Our ref: NO/2020/112855/03-L01
Your ref: 3/2020/0601
Date: 02 December 2020

**OUTLINE PLANNING FOR THE CONSTRUCTION OF UP TO 125 DWELLINGS WITH PUBLIC OPEN SPACE, LANDSCAPING AND SUSTAINABLE DRAINAGE SYSTEM AND VEHICULAR ACCESS POINT FROM HIGHMOOR PARK. ALL MATTERS RESERVED EXCEPT FOR MEANS OF ACCESS.
LAND AT HIGHMOOR FARM, CLITHEROE, BB7 1PN**

Environment Agency position

Drawing title: Flow Exceedance Plan

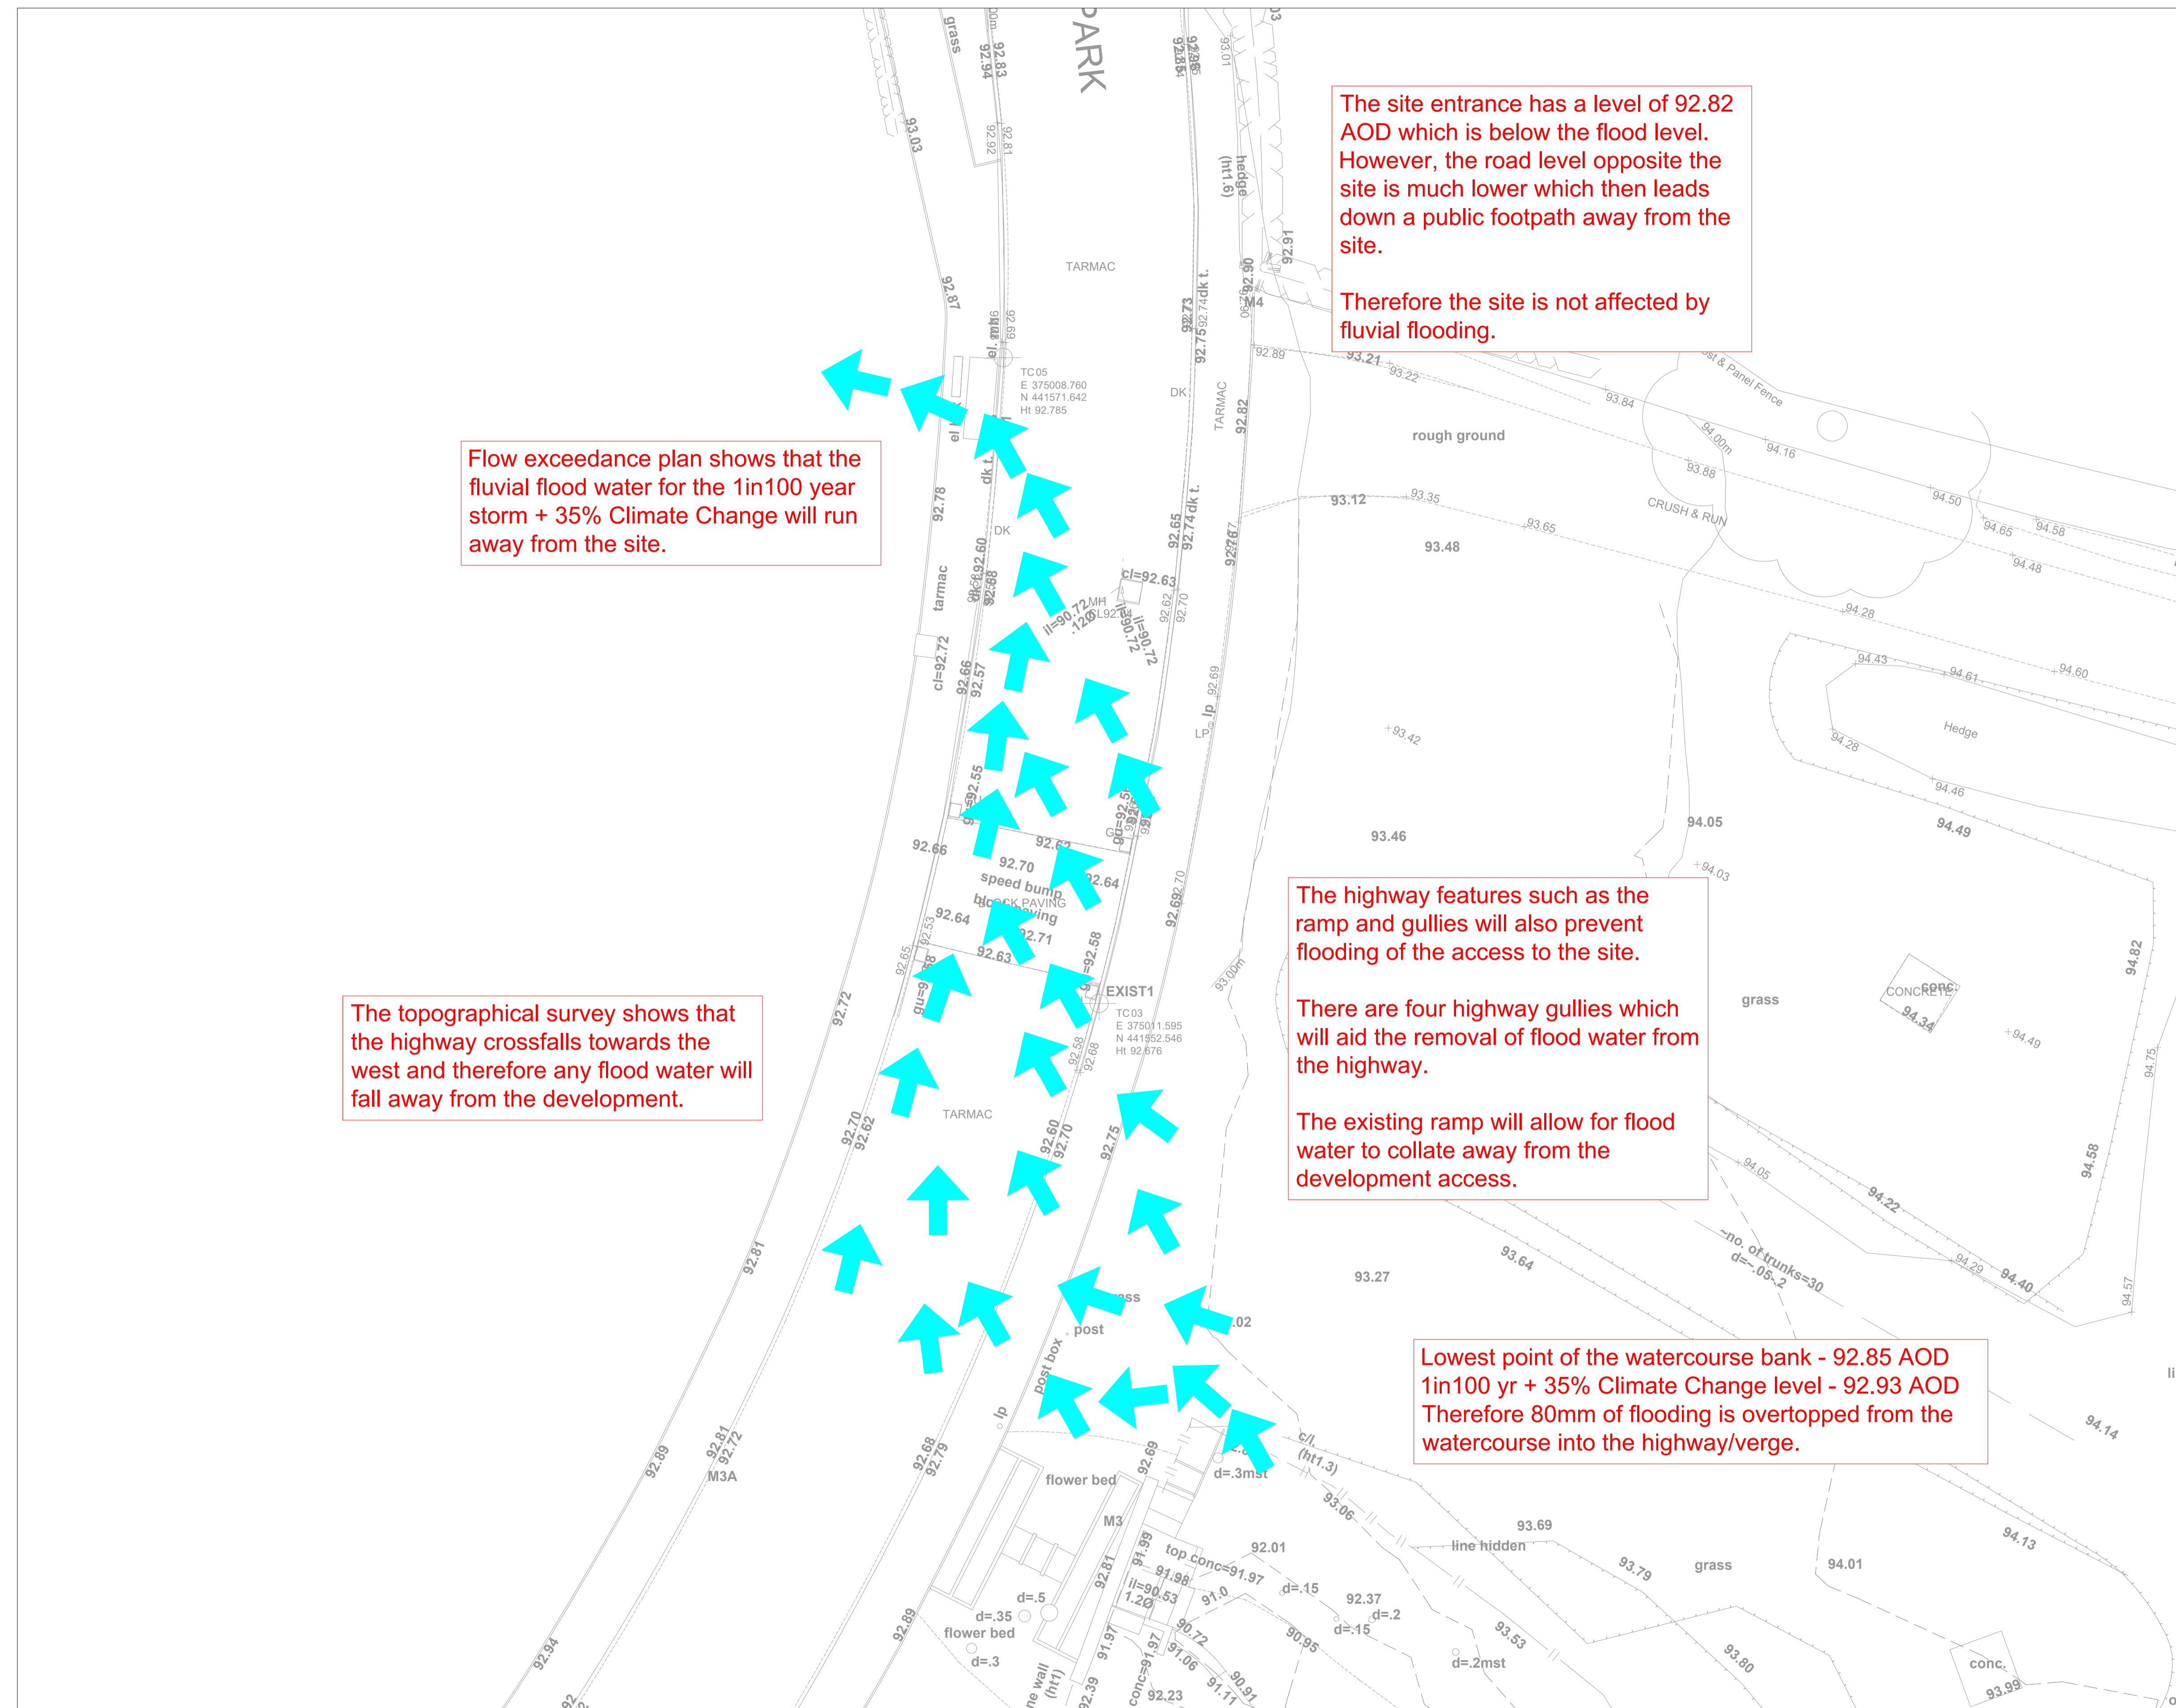
- Provide details of the proposed raising of the banks of the watercourse/flood defences. No assessment has been made to consider whether the scheme is feasible, or whether it would impact people and property elsewhere

The FRA states throughout, that the site is located in flood zone 1. There is however, a small area of the site located in flood zone 2 to the south-west which must be acknowledged.

The FRA states that the banks of the watercourse will be raised or flood defences will be put in place to accommodate the 1 in 100-year event with 70% climate change allowance. Inadequate information has been submitted in relation to design, feasibility and assessment regarding the impact on property and people elsewhere.

It is recommended that the 100-year fluvial flood event with 35% allowance for climate change level for Shaw Brook is also assessed. The modelled levels should form part of the fluvial flood risk assessment for the site, the assessment should also include analysis of flood depths, extents etc. and the risks these pose. Mitigation measures implemented must not increase flood risk to people and property elsewhere.

To overcome our objection, the applicant should provide further detail and assessment of the proposed flood defence or raising of the banks of the river. The area of the site located in flood zone 2 must also be acknowledged.
